Proposed Residential Development, Deveron Road, Huntly

Combined Stage 1 & Stage 2 Road Safety Audit

Report No. A113162 – RSA2

**RESPONSE TO STAGE 1/2 ROAD SAFETY AUDIT
 22/04/19**

ROAD LAYOUT PLAN (1:250)

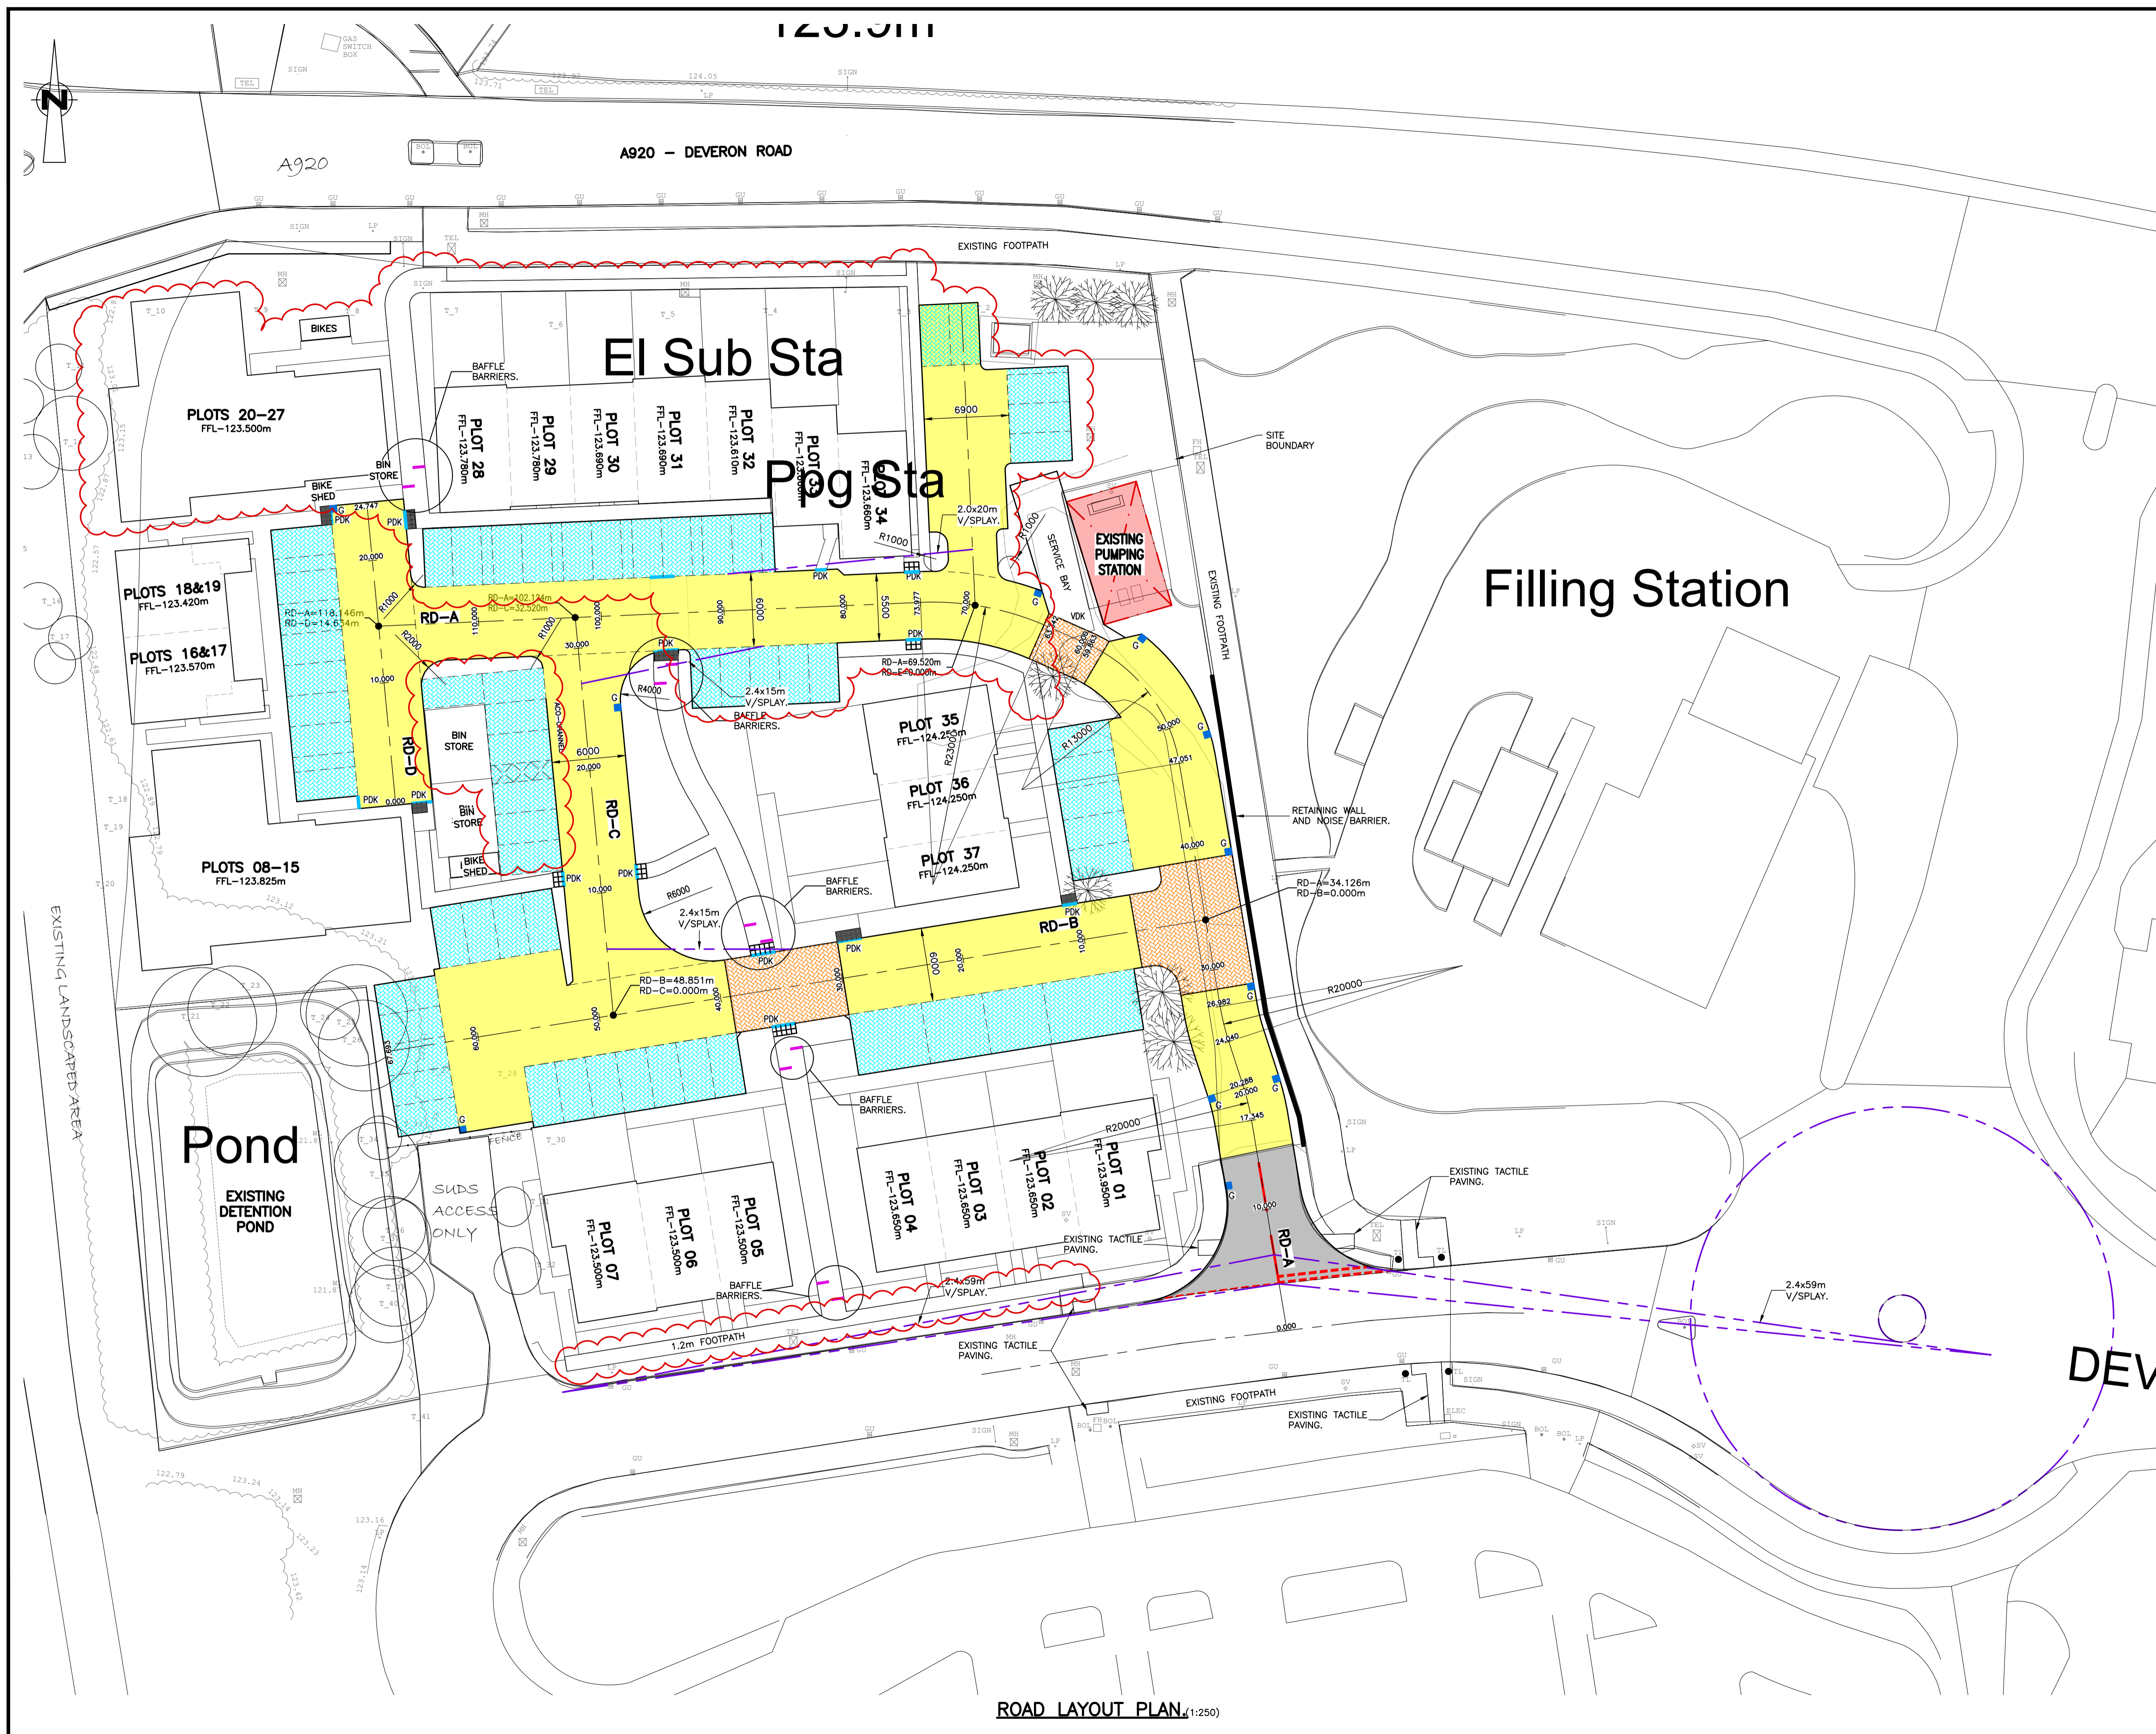
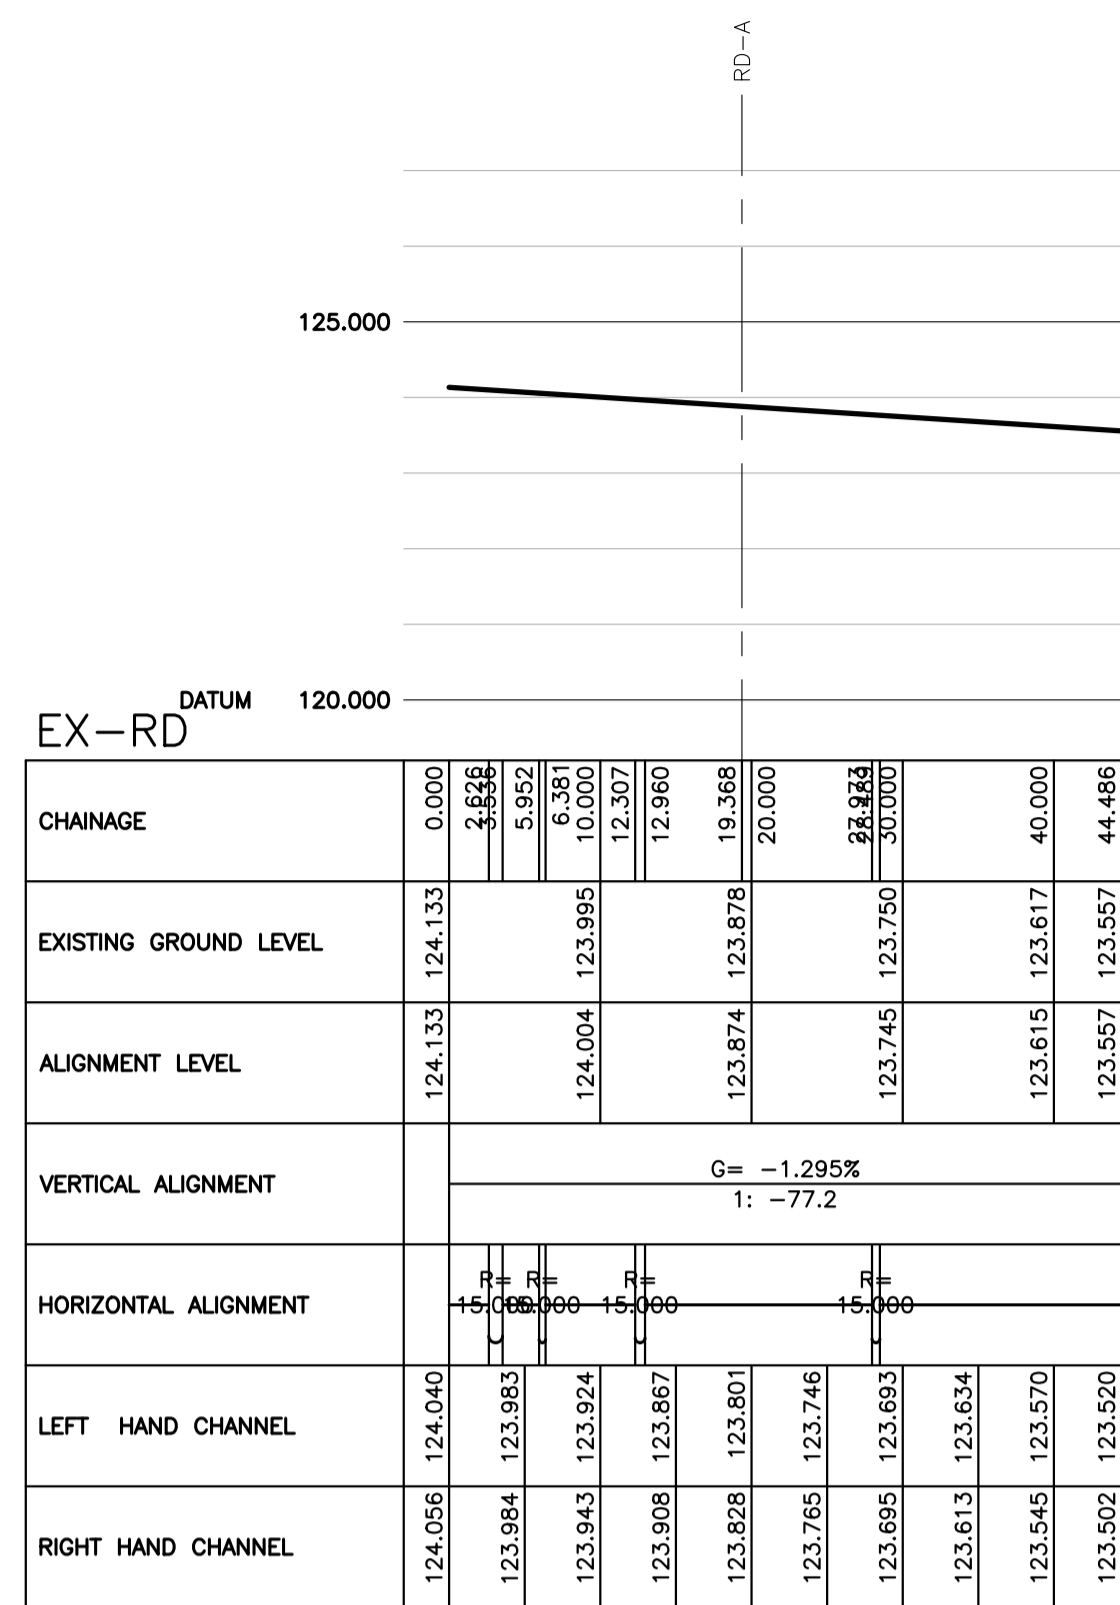
The existing substation and pumping station located to the north east of the site currently have access from the south with an area for engineers to park while working on the equipment. The proposed scheme layout does not indicate an area for maintenance vehicles. This could result in vehicles driving on and obstructing the shared footway cycleway and risking collisions with pedestrians and cyclists.

It is recommended that provision is made to allow safe access to the equipment for service vehicles.

Dropped kerbs have been indicated on the central pedestrian path, however no tactile paving is proposed. In addition to this, no dropped kerb access is shown to allow users from the development to access the shared footway/ cycleway to the east of the site. A lack of these facilities can lead to an increased risk of accidents for pedestrians and cyclists accessing or crossing at these facilities, particularly those with visual or mobility impairments.

It is recommended that tactile paving be provided at all crossing points within the site and dropped kerbs be provided to allow access to the shared footway/ cycleway.

The alignment of the paths between unit 4 and 37 do not align with each other and are staggered. This alignment will make it difficult to provide correctly aligned tactile paving and may create a trip hazard for visually impaired pedestrians (See Problem 2).

It is recommended that the paths be aligned to allow provision of tactile paving.

The site has been designed with path provision from the north to the south of the site with what appears to be a shared use road layout where pedestrians are to walk on the carriageway to access the properties with some narrow paths providing some connections.

It is recommended that either footpaths be extended to provide a fully connected network through the site or a full block-paved surface be provided with contrasting surface colours to indicate safe pedestrian areas and aid with navigation for partially sighted pedestrians.

No details are shown at this stage as to a proposed change in speed limit at the access junction. As traffic calming is proposed in the form of build outs and also with a shared use road layout, it is expected the design would propose a speed limit of 20 mph. This could create confusion and result in vehicles travelling at excessive speed, putting pedestrians at risk of being struck within the site. It was noted during the site visit that the site to the east was signed as a 20 mph zone and the site to the north also as 20 mph with home zone signing (See Figure 3).

It is recommended that 20 mph zone signing be provided at the site access.

No road markings are proposed at the site access junction. With no priority markings at the junction, there is a risk that drivers will fail to give-way, resulting in collisions.

It is recommended that give-way markings are provided at the access junction.

A service bay has been incorporated into the layout to accommodate maintenance vehicles without obstructing vehicles on the proposed access road.

Tactile paving has been incorporated into the layout. A proposed crossing point has been incorporated from the existing shared footway / cycleway to the shared surface road.

The central footpath have been realigned to be opposite one another.

The shared surface areas will have HRA with red coated chippings to aid with navigation for partially sighted pedestrians.

Signs to Diagram 674 and 675 have been incorporated into the layout.

Give way markings have been incorporated into the layout.
